From: David Boarer [REDACTED]
Sent: 03 December 2018 14:19
To: Michael Eastham
Subject: RE: 1006-Ang102F-Proposed Materials.pdf - A/82/18/DOC - FIRE HYDRANTS - Quiet Waters, Roundstone Lane, Angmering

Planning Application: A/132/17/OUT & A/82/18/DOC

Address: Quiet Waters, Roundstone Lane, Angmering

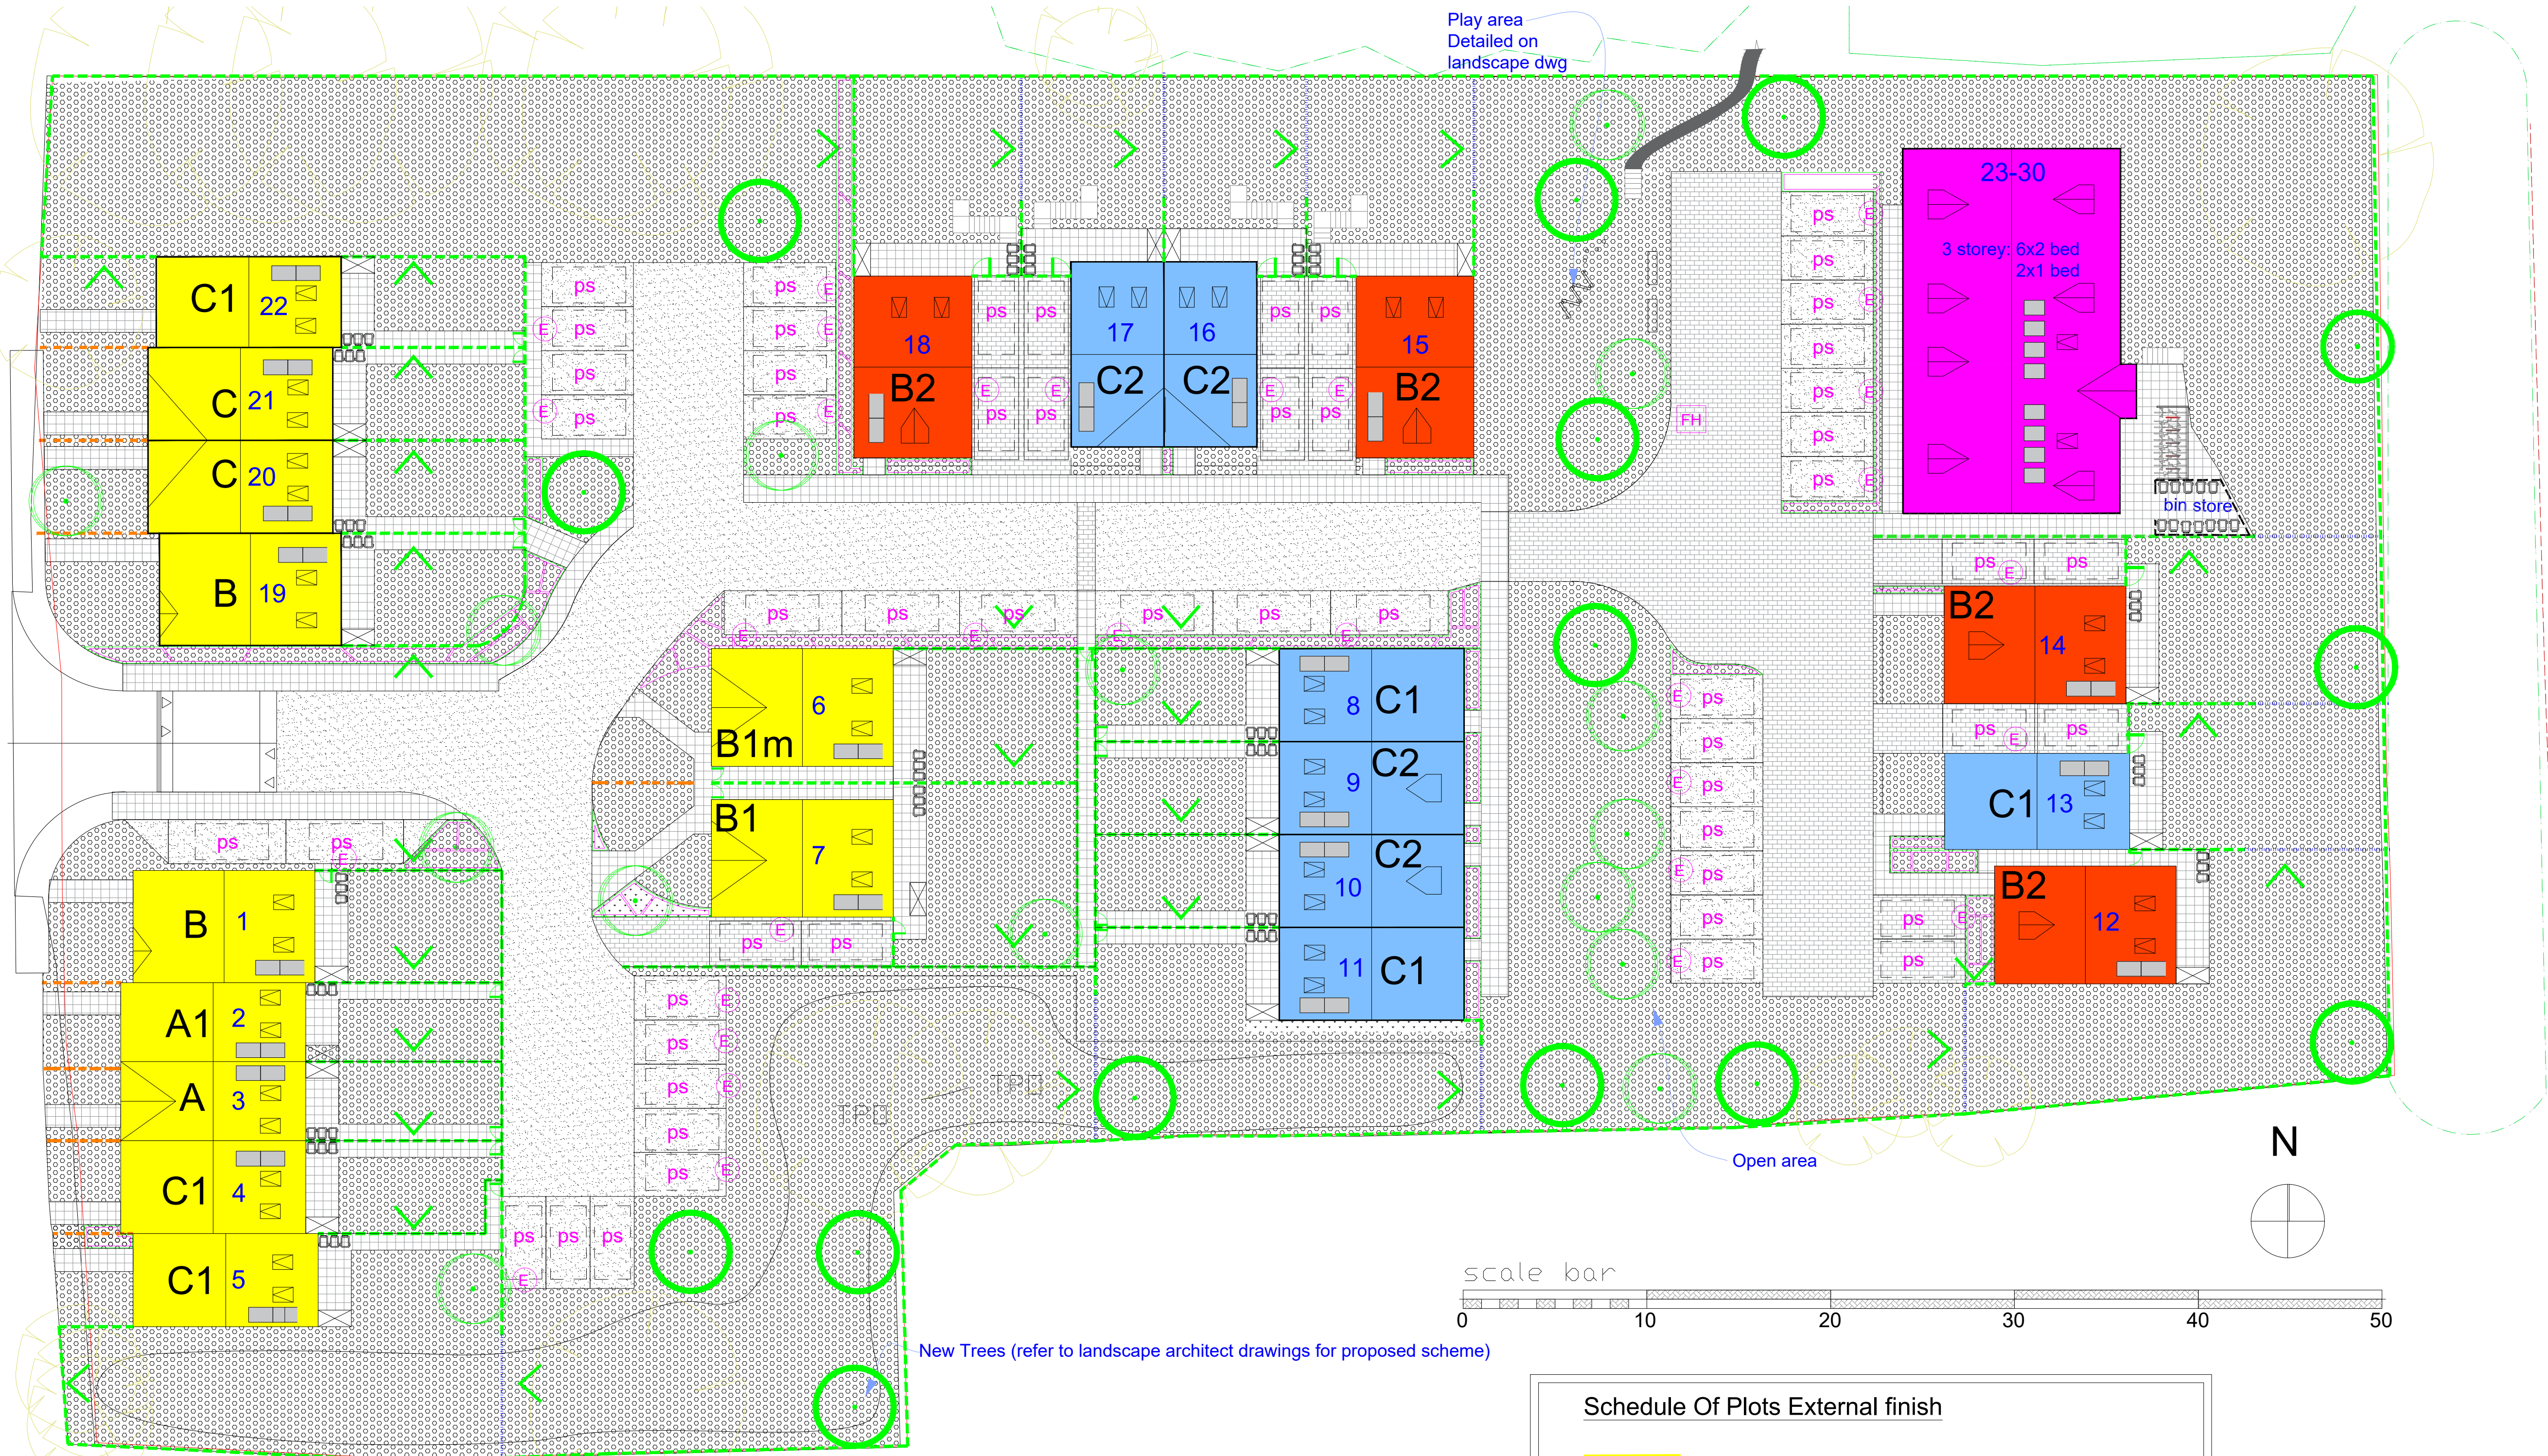
I have reviewed the proposed location of the fire hydrant as submitted in Plan Ang102 and accept this location as suitable for firefighting to serve WSFRS operations. This releases part one of the condition and when connected to a main suitable for firefighting WSFRS will attend to test the installation to release the condition in full.
